[REDACTED]  
The Pumping Station, Darnicle Hill, [REDACTED]  
[REDACTED]  
[REDACTED]

23 November 2022

Re: applications:

- *6/2022/2524/PN8 - 2 single storey side extensions*
- *6/2022/2525/PN8 - 2 single storey rear extensions*
- *6/2022/2526/PN27 - Additional storey to additional height of 2.8m*

[02] SITE PLAN 1:200

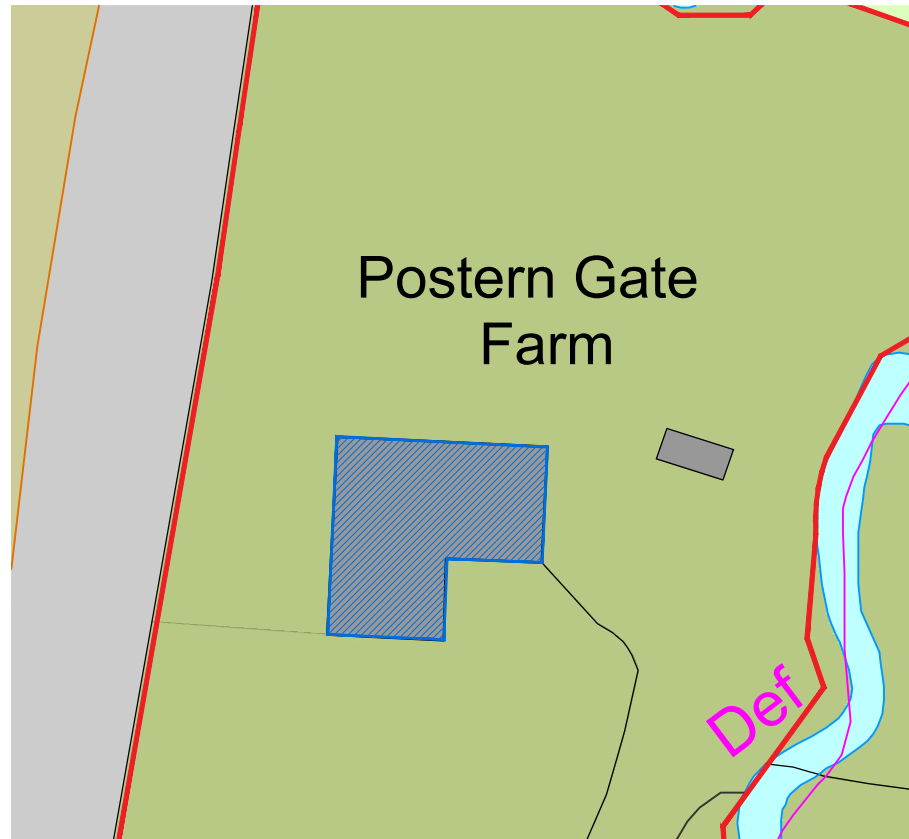
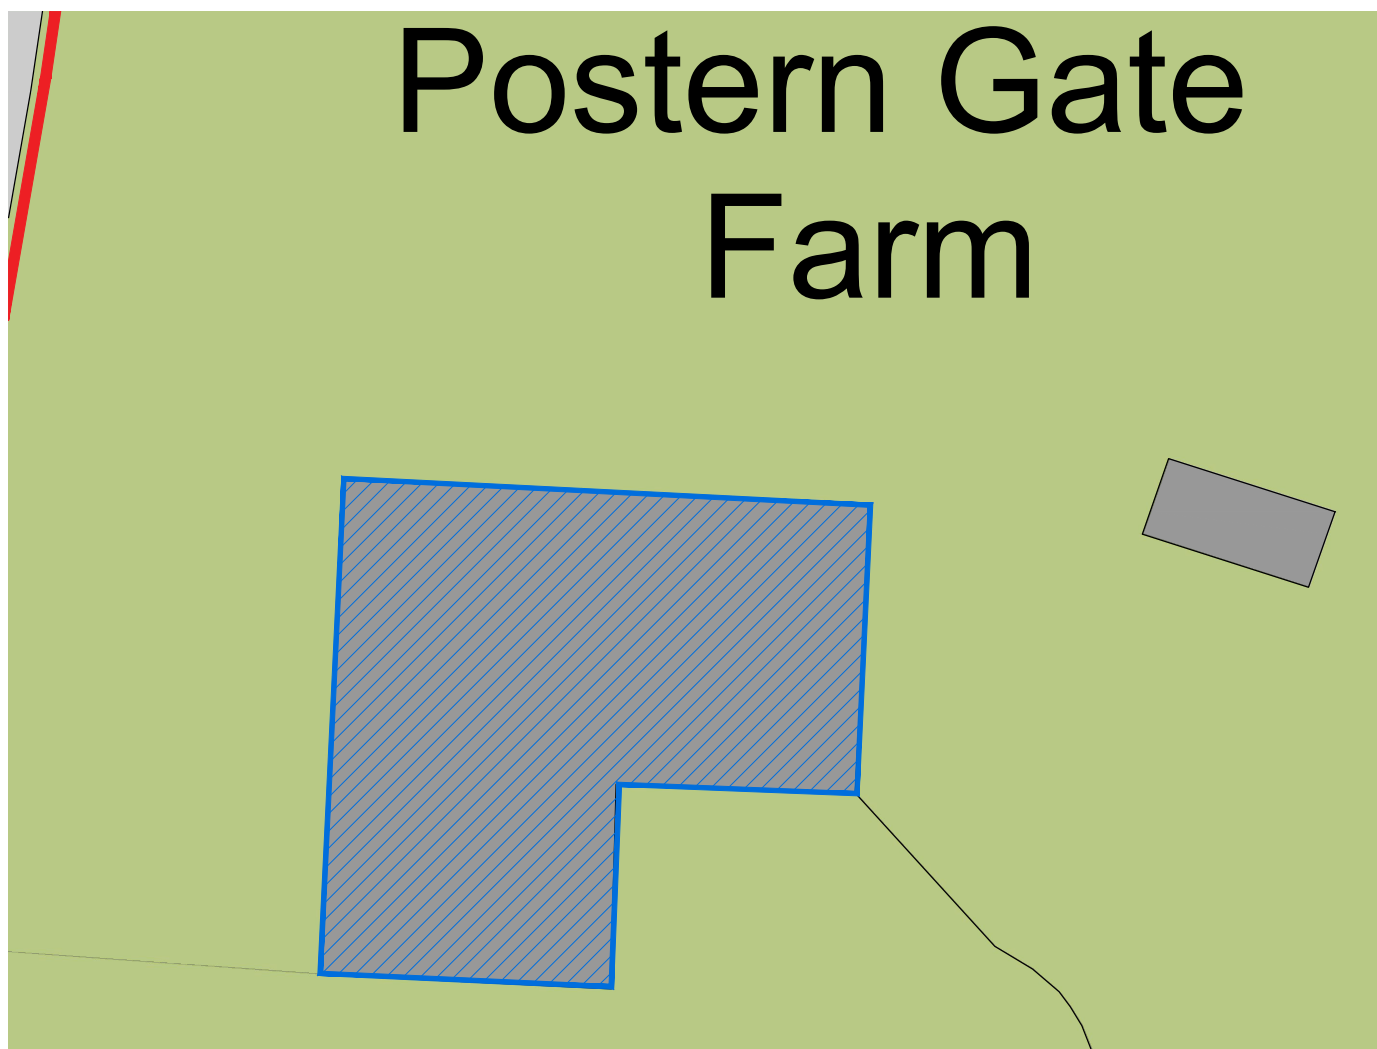
- would be obtrusive from our garden view, whereas a bungalow retains the existing rural view. For the neighbouring houses across the other side of the railway line the two storey building would I believe form a visual incursion towards the Woodland Trust's Wormley Wood from their elevated position.
- a second storey will come in line with the close by railway line and be impacted by the significant railway noise for current and future inhabitants, whereas a bungalow has the opportunity for some shielding through its height and the courtyard opportunity of scheme 2524/PN8. We note that the railway line is not shown on the site plan and yet is close to the existing building.
